Outline application with some matters reserved for demolition of existing detached dwelling & erection of 2 no. 5 bed dwellings, double garage & alterations to existing access

69 Coastal Road Kingston

Thank you for your internet representation made on 5th January 2012 which has been recorded as **an objection** with the comments as follows:

Rev A: Windows to bedroom/fairly corrected				Nov 2011	
REVISION					
PROJECT					
Proposed development at 'Simcar' Coastal Road, East Preston					
SUBJECT					
Plot 2 - Indicative Plans and Elevation					
SCALE		DATE		DRAWING No	
1:100		Nov 2011			
DRAWN		CHECKED			
11 / 46 / 03				Rev A

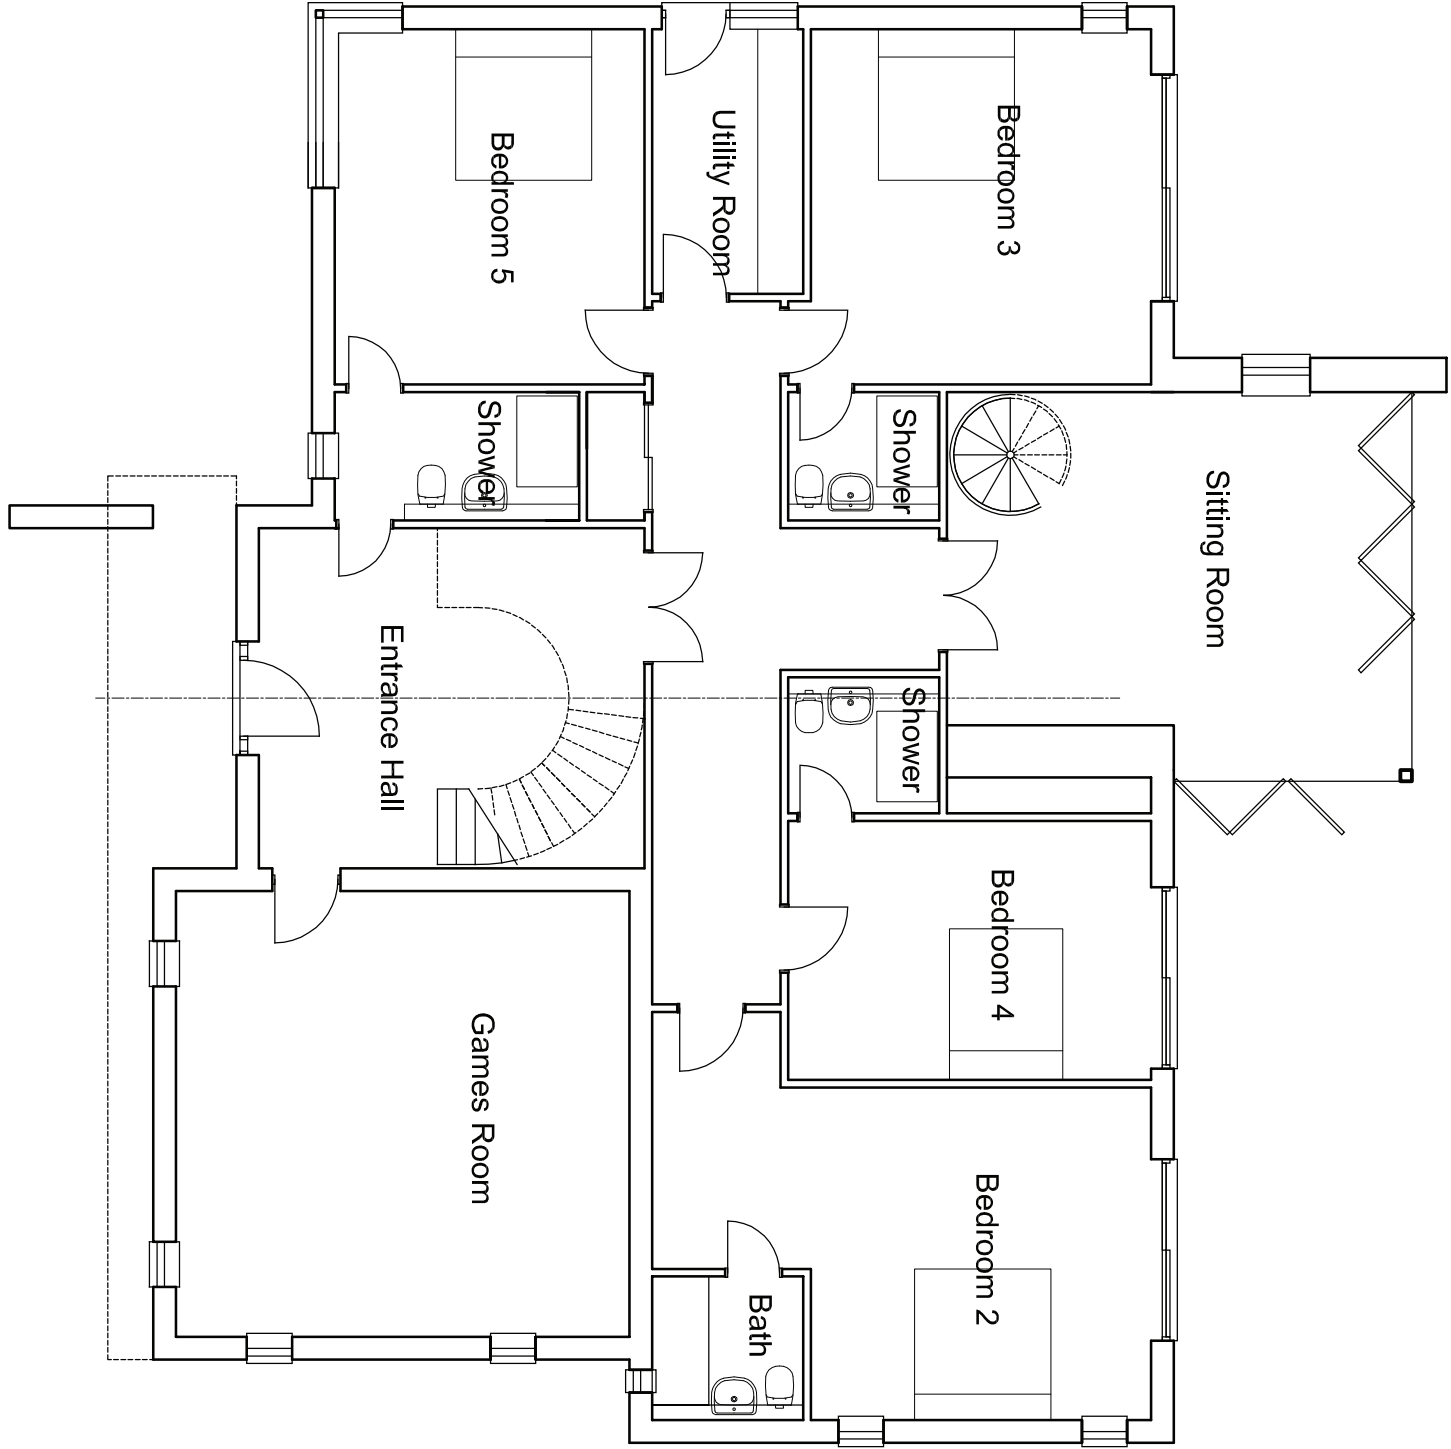
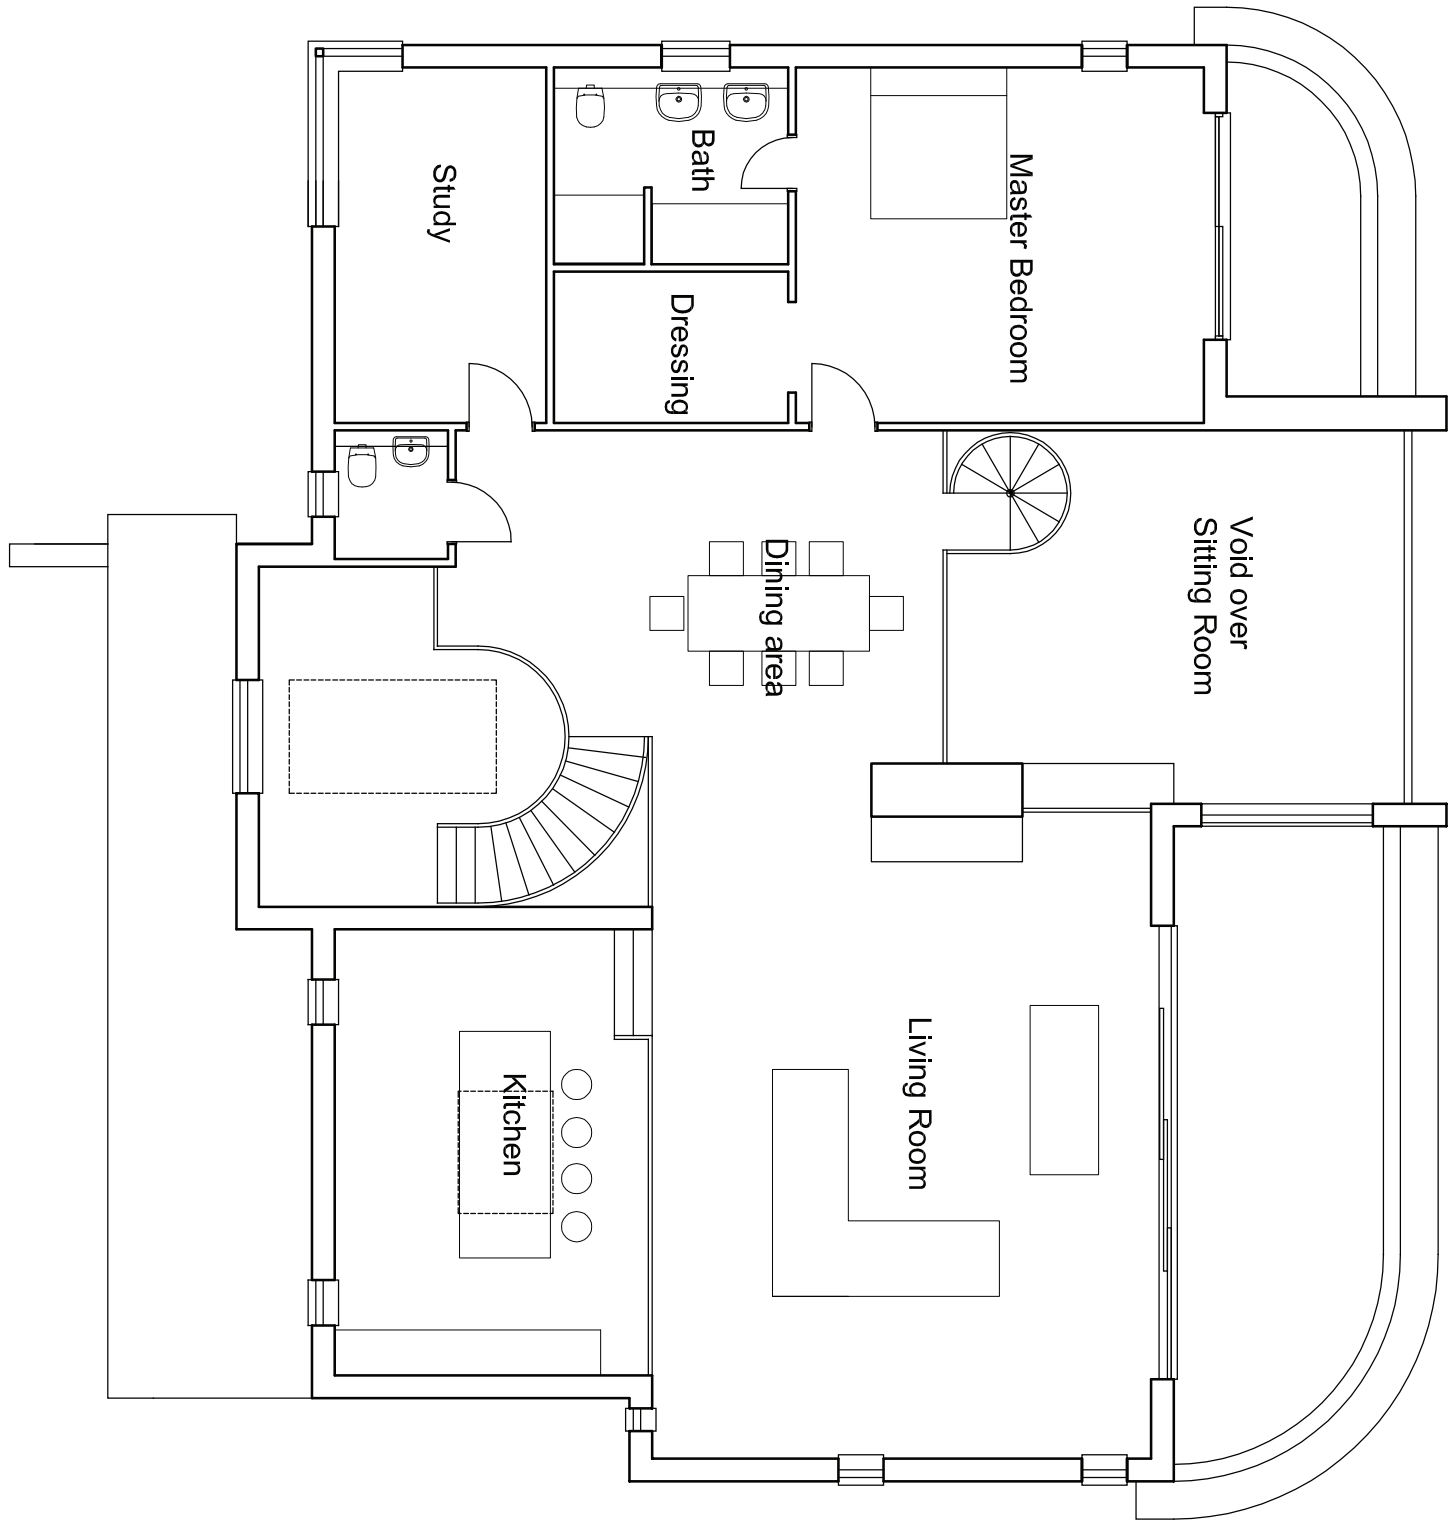
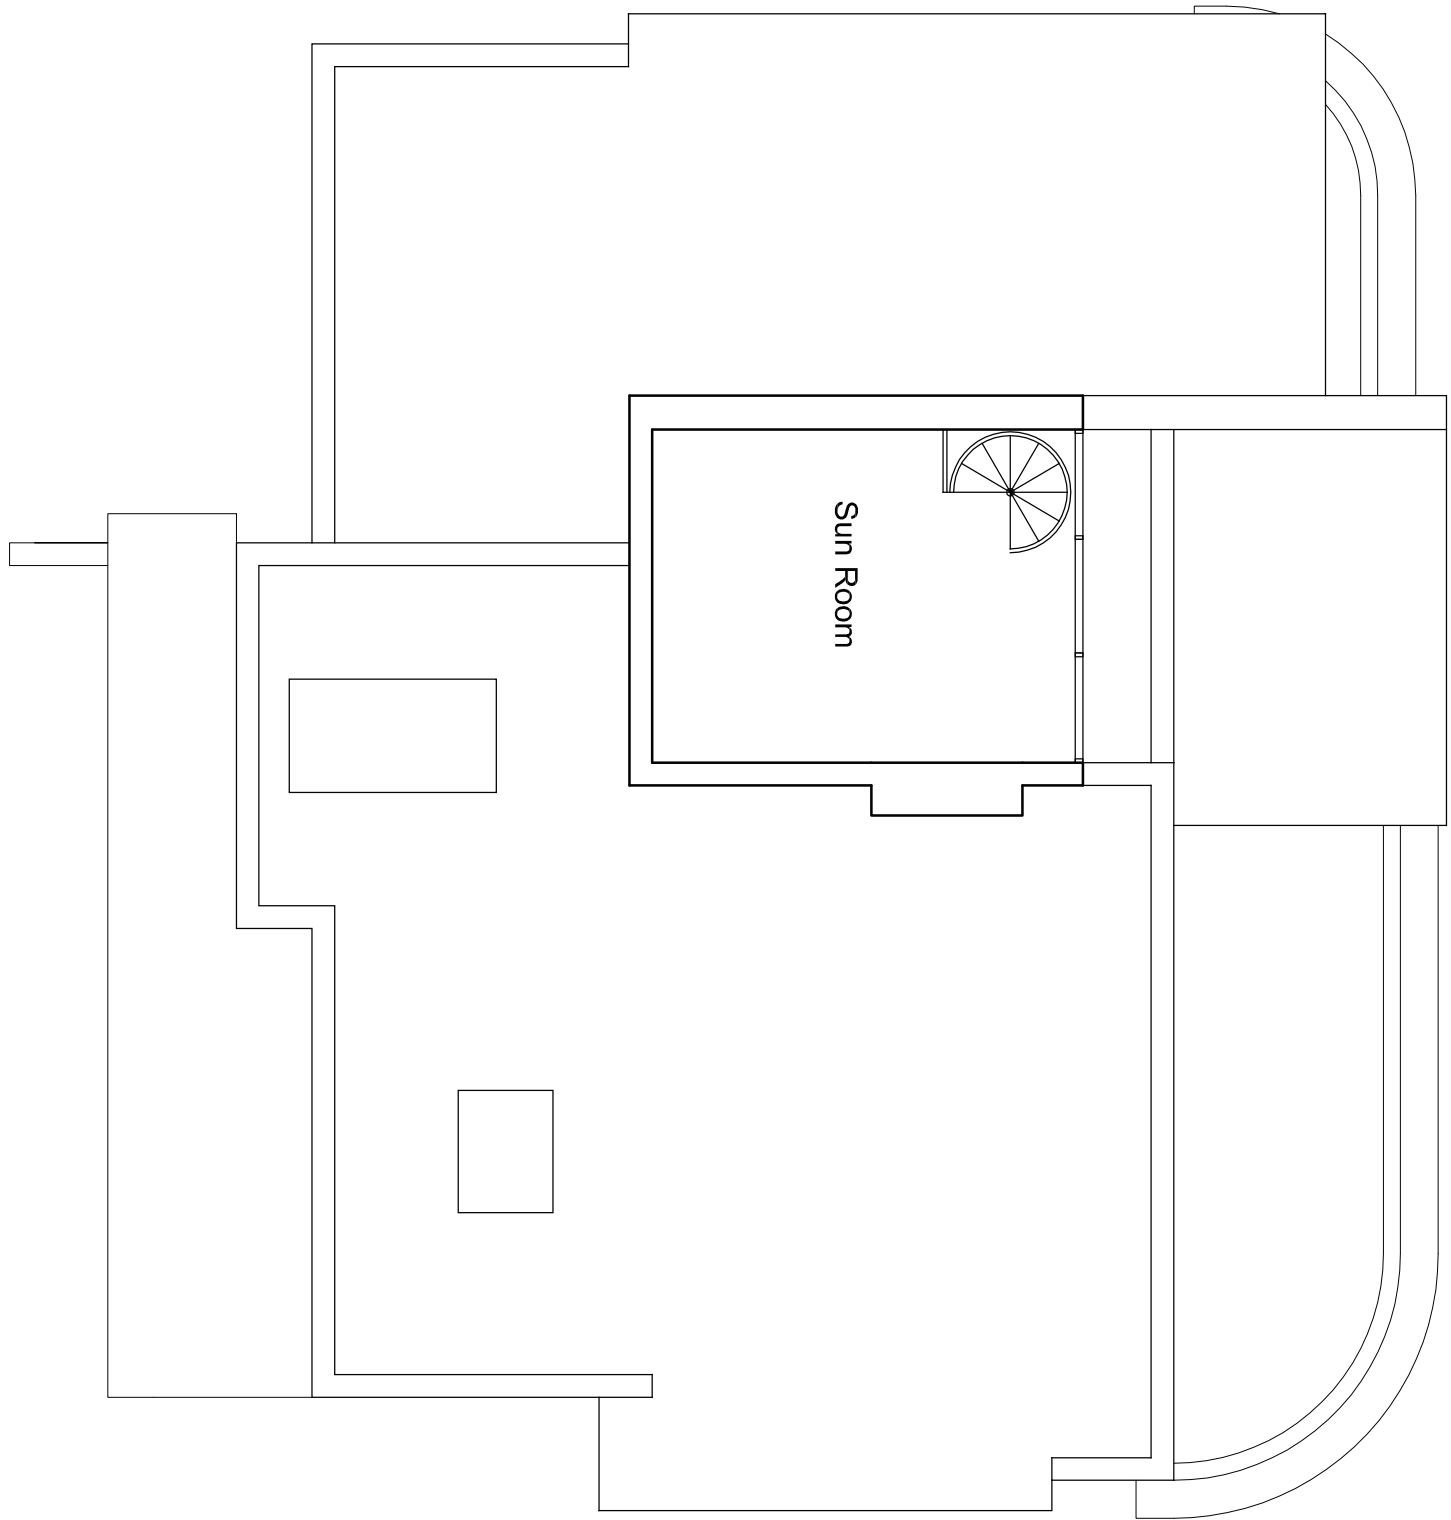
1. The proposed houses are to be built further south than the existing which will spoil the line as you look along the West Kingston greensward. This repositioning will also afford the new house direct views of our garden and into the back of our house which the current house does not have.

5. The terraces on the first floor will directly overlook both our garden and into the back of our house. We would ask that if you do allow this, they be screened so as to only afford a view south towards the sea.
